Application number: 2025/91576	
What is the application for?:	Erection of detached dwelling
Address of the site or building:	Land adj, 47, Cresswell Lane, Heckmondwike, WF13 4PJ
Postcode:	WF14 8NF

Planning Objection: Loss of Access, Inaccurate Access Plans, and Impact on Local Wildlife

SITE PLAN 1:500

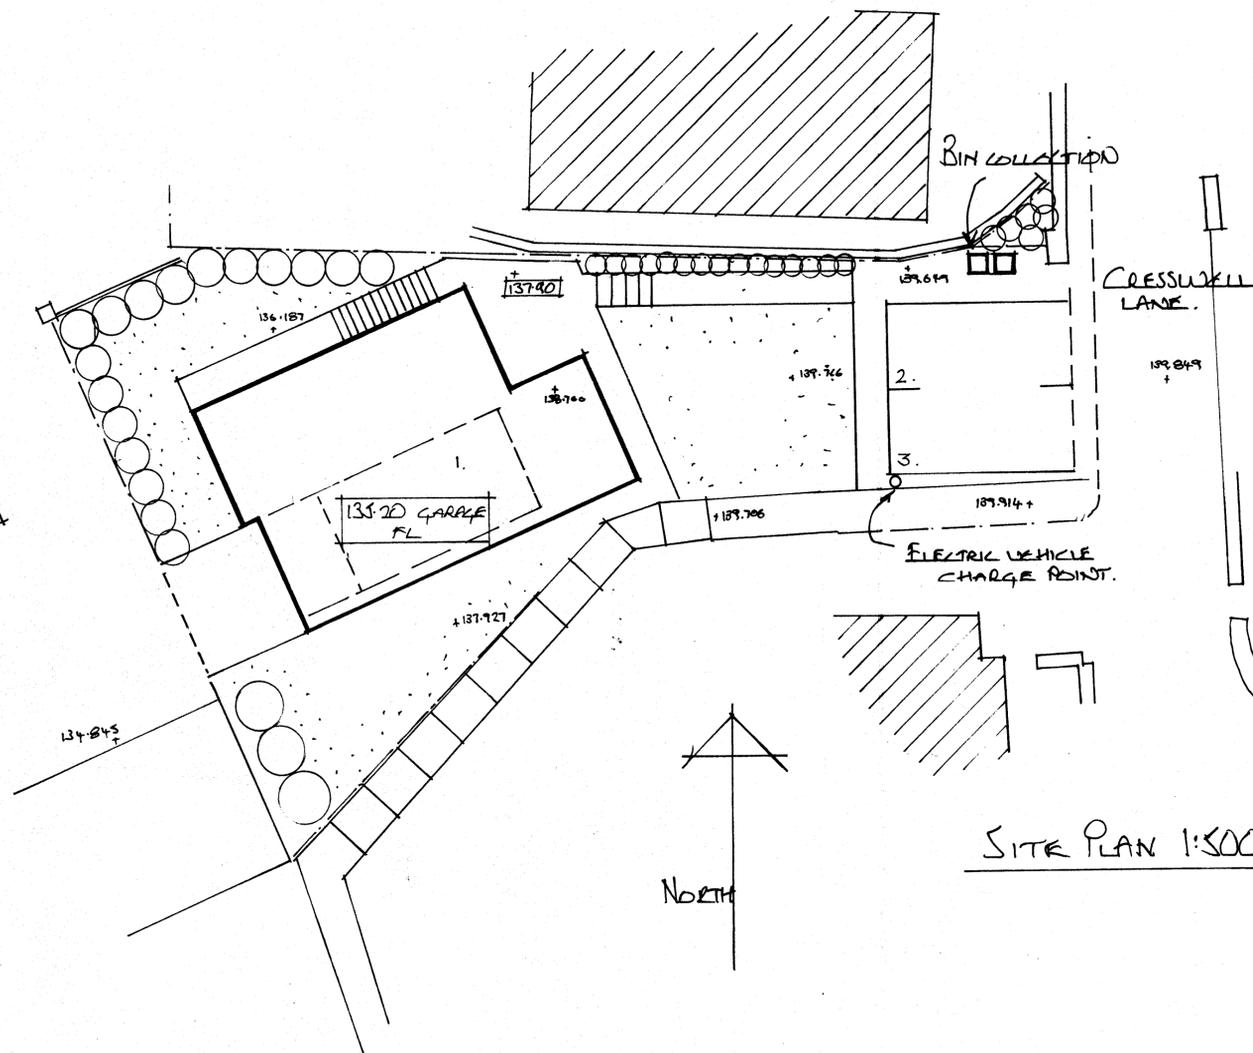
The proposed building will obstruct access to the existing garages. The plans show a diagonal line cutting across the turning circle at the end of the garages. This area is essential for vehicles to turn and manoeuvre safely when entering or exiting the garages. Any reduction in this space will make access difficult or impossible for garage users.

The submitted drawings incorrectly indicate access to the proposed property through the Lindale Mews area. There is no legal or practical access through Lindale Mews. The original previously approved plans for this site clearly showed the access via Creswell Lane, not through Lindale Mews. The current plans are therefore inconsistent with the original approved access arrangements.
